# KITTITAS COUNTY

### MEMORANDUM

**SUBJECT:** Mynar BL-14-00007

PROPOSED

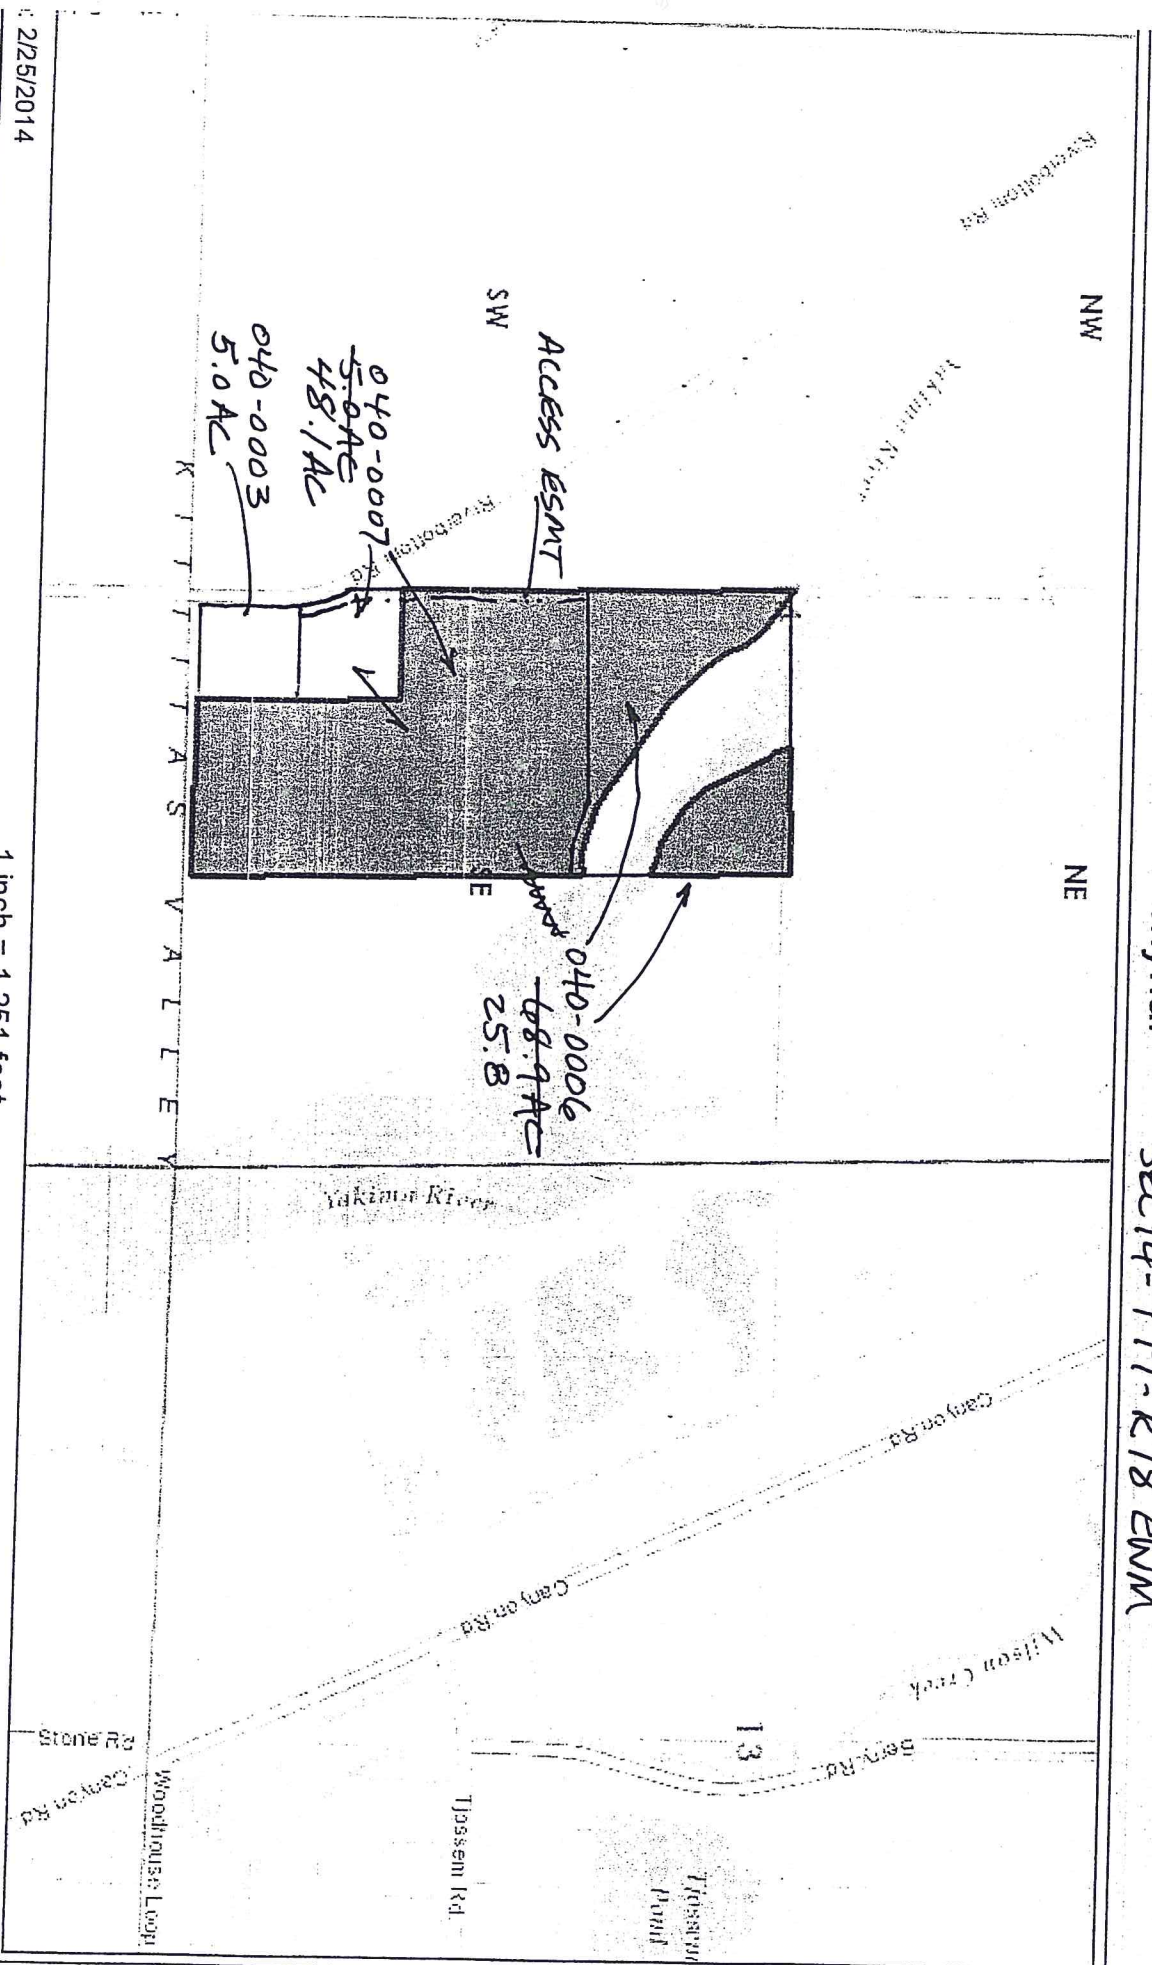
The Mynar boundary line adjustment proposes a parcel that is entirely within the floodway. Development within the floodway is highly restricted. New residences are not allowed within the floodway and non-residential development is not allowed unless certification by an engineer is provided which demonstrates through hydraulic and hydrologic analyses that no increase to the base flood elevation will occur due to the project (KCC 14.08.300).

The definition of boundary line adjustment includes a provision which prevents the alteration from creating a parcel containing insufficient area to meet minimum requirements for a building site (KCC 16.08.055).

It my professional opinion as a certified planner and floodplain manager that a parcel entirely within the floodway does not contain sufficient area to build due to the restrictions placed upon the property. I do realize that not all parcels are proposed for development, and may remain in agricultural use or placed into conservation. Additionally, this parcel may be proven to be suitable for non-residential development through the engineering certification process. For these reasons, I requested a notice to title be recorded on the parcel within the floodway, which will assist in notification of special flood hazard areas in the future and ensure the landowner takes responsibility for the action of creating a parcel with limited development potential.
